Application by Net Zero Teesside Power Limited and Net Zero North Sea Storage Limited for the Net Zero Teesside Project The Examining Authority's written questions and requests for information (ExQ1) Issued on 19 May 2022.

The following table sets out the Examining Authority's (ExA's) first round of written questions and requests for information – ExQ1. Questions are set out using an issues-based framework derived from the Initial Assessment of Principal Issues provided as **Annex C** to the Rule 6 letter of 11 April 2022. Questions have been added to the framework of issues set out there as they have arisen from representations and to address the assessment of the application against relevant policies.

Drawing file: EN010103 / EN010103-002120-NZT DCO 6.3.69 - ES Vol II Figure 17-3 Landscape Character Plan August 2022 (D6).pdf

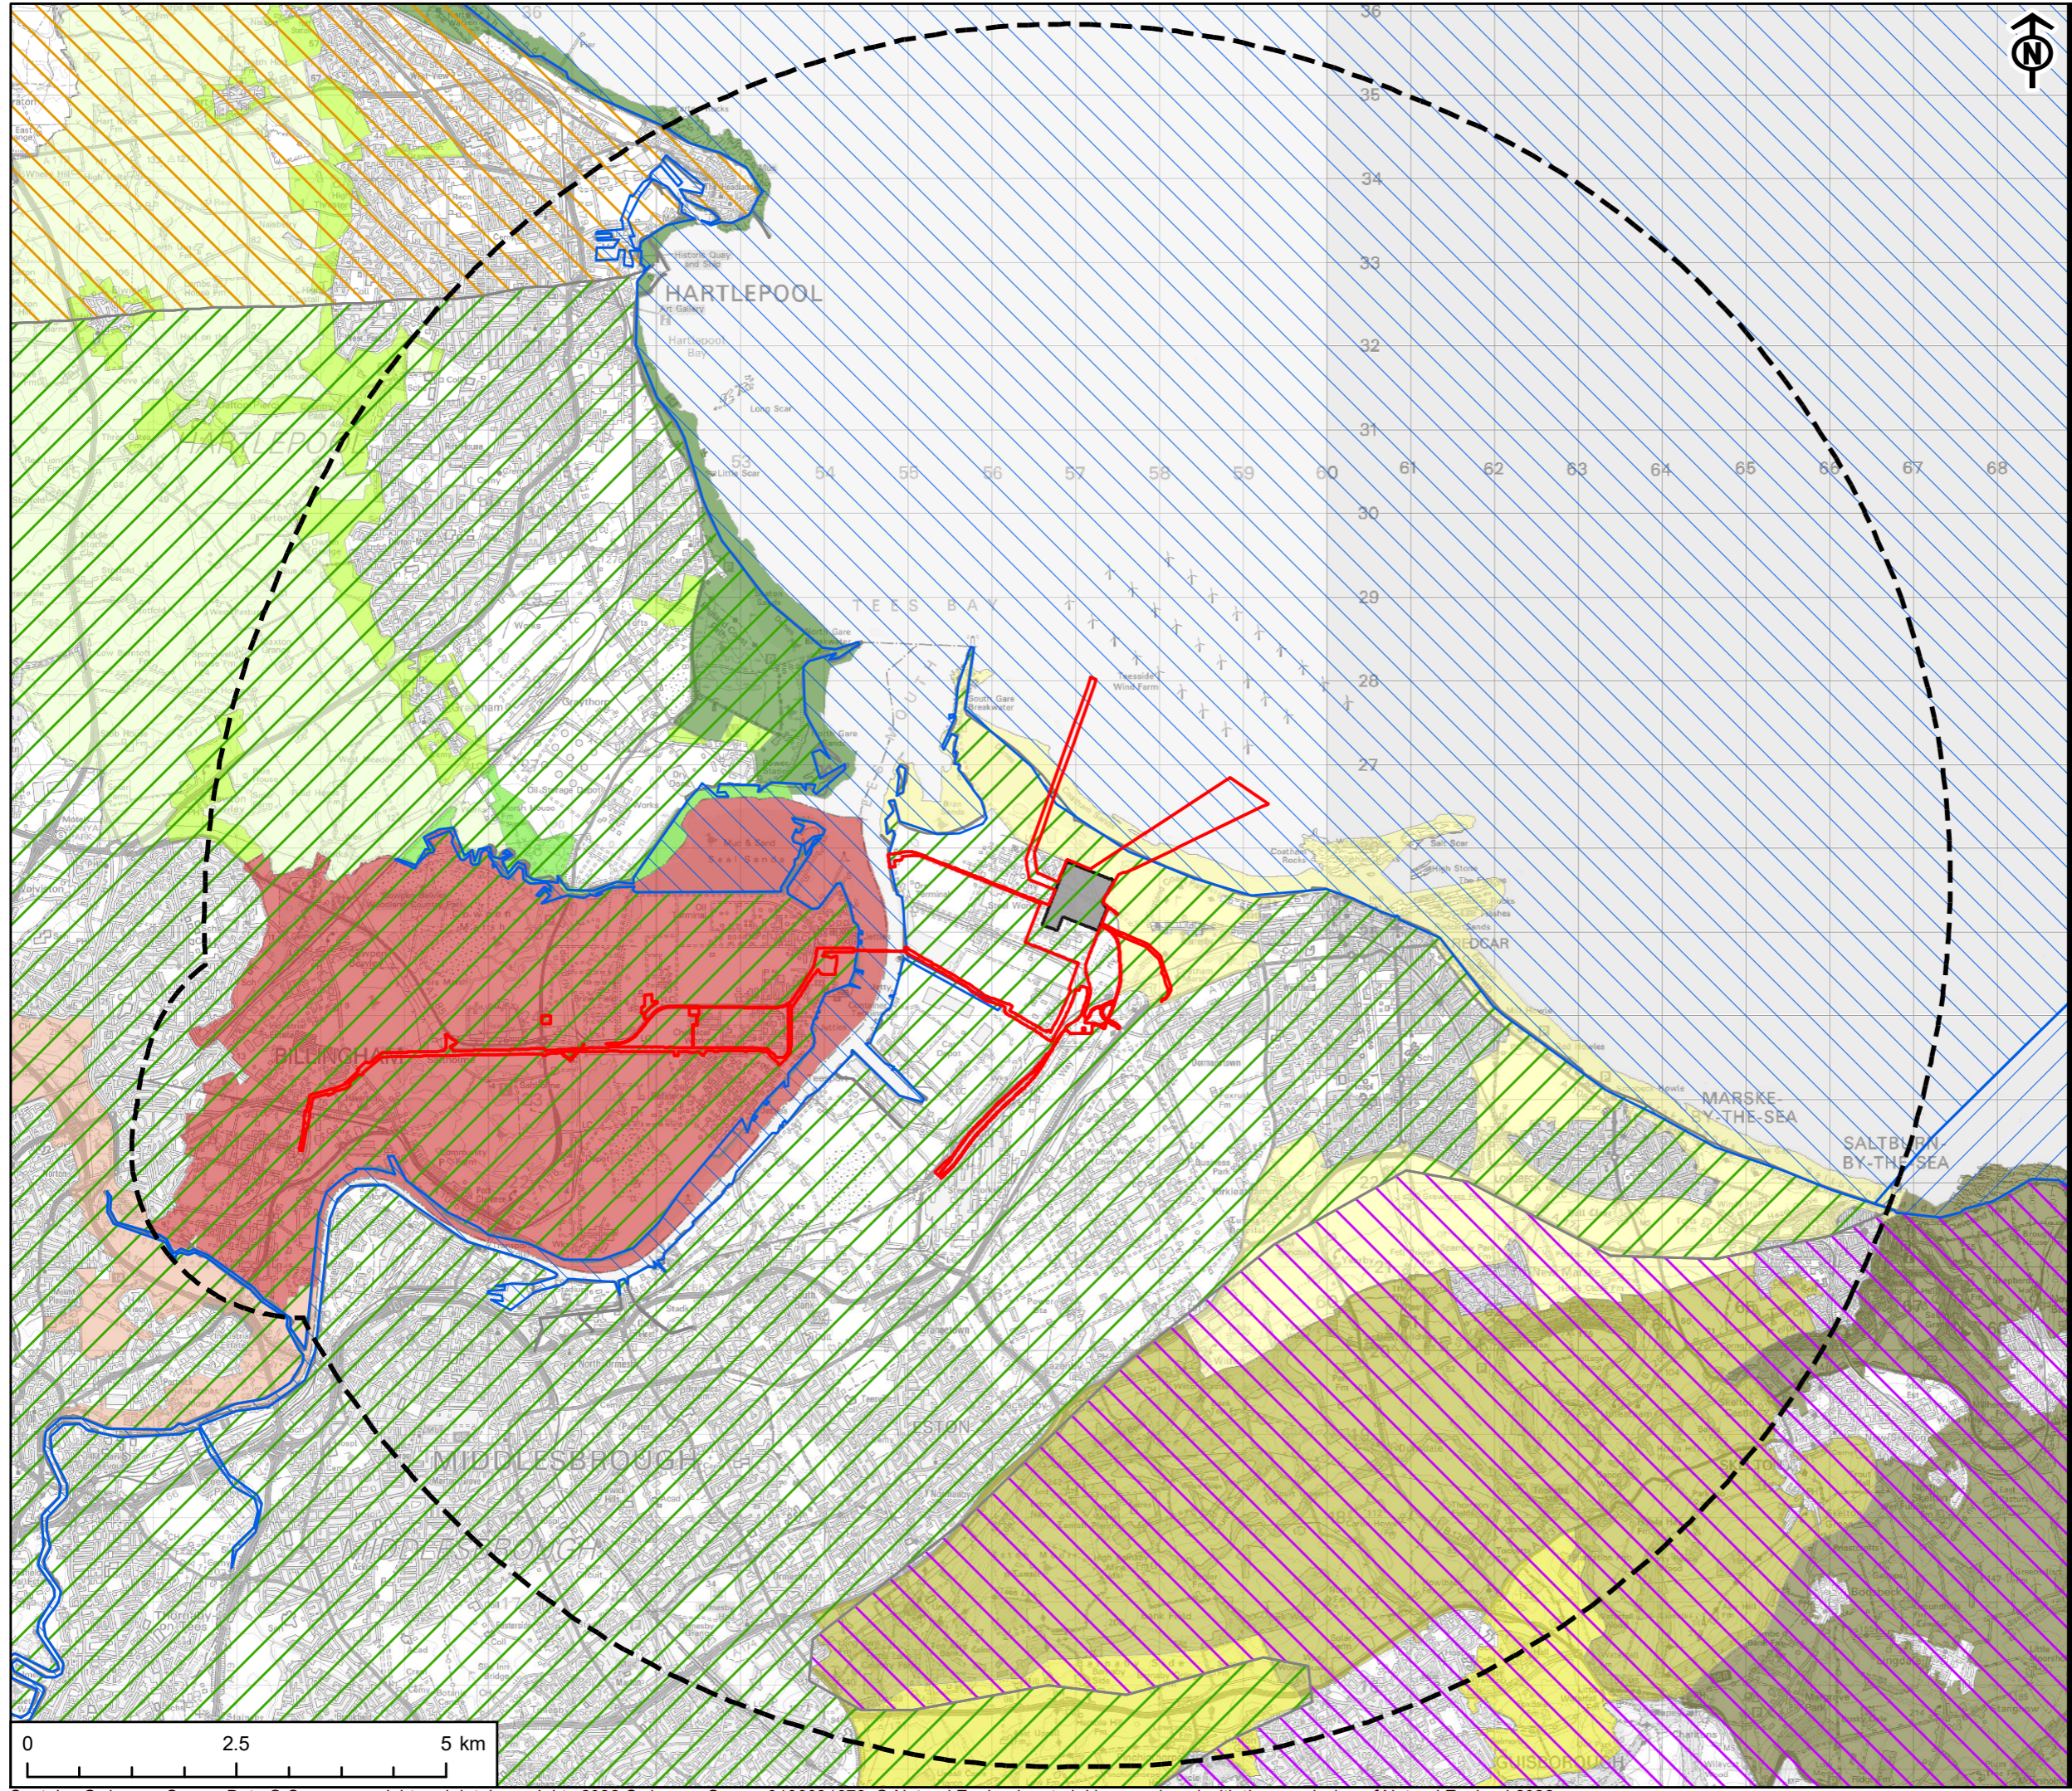
ExQ1	Question to:	Question:
	RCBC	edge of the landscape study area. The ExA noted on their USI [EV1-001] that there are clear views of the existing steel works structures from the seafront and the pier. No part of this area is indicated on Figure 17-4 as a potential viewpoint location. The Landscape Character Plan at figure 17-3 [AS-120] indicates that this is on the boundary of a number of different national and local LCAs as well as the North Yorkshire Coastal Waters marine character area.
		Can the Applicants:

i) Explain why the Saltburn-by-the-Sea area was not considered as a potential viewpoint?
		Can RCBC:
		ii) Provide comment whether a viewpoint is necessary from this area, and if so, from what location.
		It is acknowledged that the applicant has sought a 5km buffer for view points on which Saltburn is on the edge of. While the ZTV at figure 17-4 shows some potential for views these have been referenced and considered as part of the Conservation Area Appraisals which make reference to nearby heavy industry.
